From: Jennen Kinchington [REDACTED]
Sent: 26 May 2021 17:30
To: Anita Gardner <Anita.Gardner@arun.gov.uk>
Subject: Re: FW: LU/287/17/PL 46a - 47 Pier Road Littlehampton

Southern Water have responded to say they cannot recommend discharge of condition 8 relating to surface water drainage.

P5	NOTE 17 ADDED AND KEY UPDATED.	20.05.21	MGC
P4	AMENDED TO SUIT SOUTHERN WATER COMMENTS	22.02.21	MGC
P3	DRAINAGE AMENDED TO SUIT LLFA COMMENTS	15.01.21	MGC
P2	MANHOLE SCHEDULES ADDED	10.12.19	MGC
P1	PRELIMINARY ISSUE	04.12.19	MGC
REV	AMENDMENT	DATE	CHKD

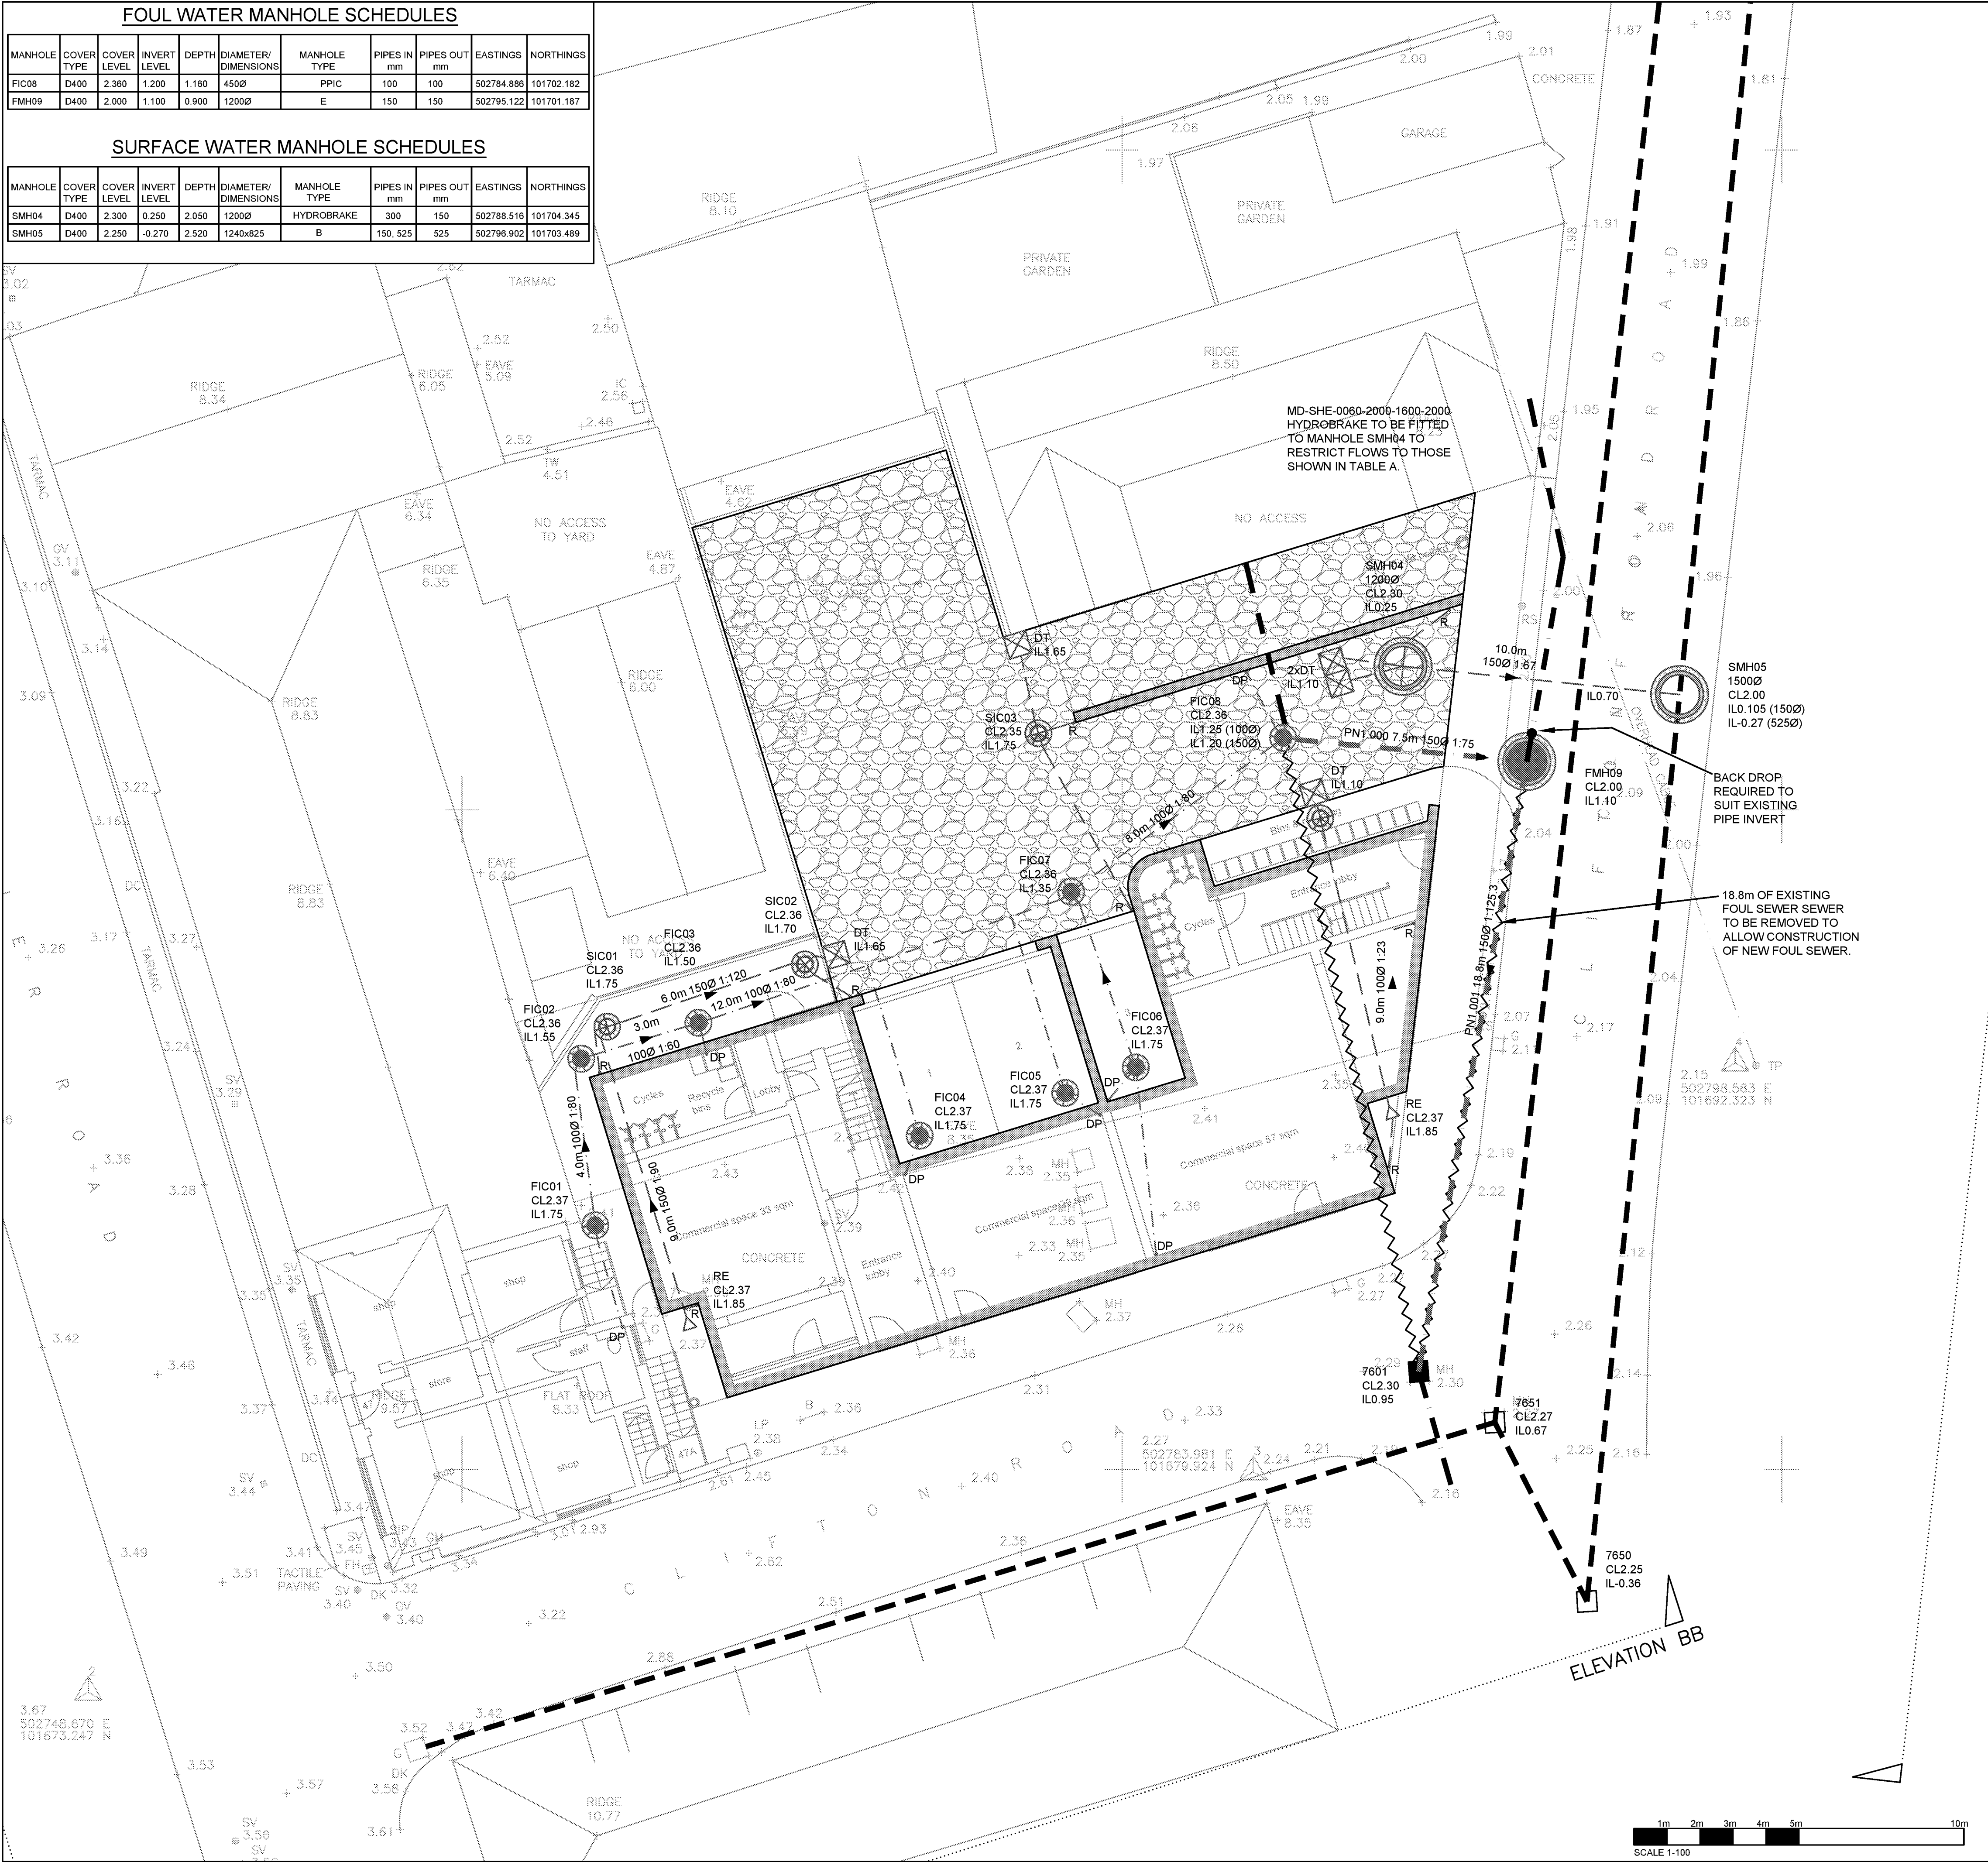
They state 'Drainage from the attenuation tank is communicating to the Southern Water public sewerage systems. Please note Attenuation tank should be sealed with impermeable membrane to avoid ingress of ground water. The design of drainage should ensure that no land drainage or groundwater is to enter public sewers network.

The drainage strategy report demonstrates that the post development surface water flows from the development are reduced from the current flow contributions. Surface water may be discharged to the existing sewer, provided the rate of discharge to sewer is no greater than existing contributing flows.'

Please find attached the amended drawings showing that an impermeable membrane will be constructed at the base of the sub-base storage system to prevent the migration of ground water into the Southern Water sewer. In any event this will be unlikely as the soils are of clay content with poor infiltration characteristics.

As you can see from table A on drawing 10 the post-development flow rates are significantly lower than pre-development so all the boxes are now ticked.
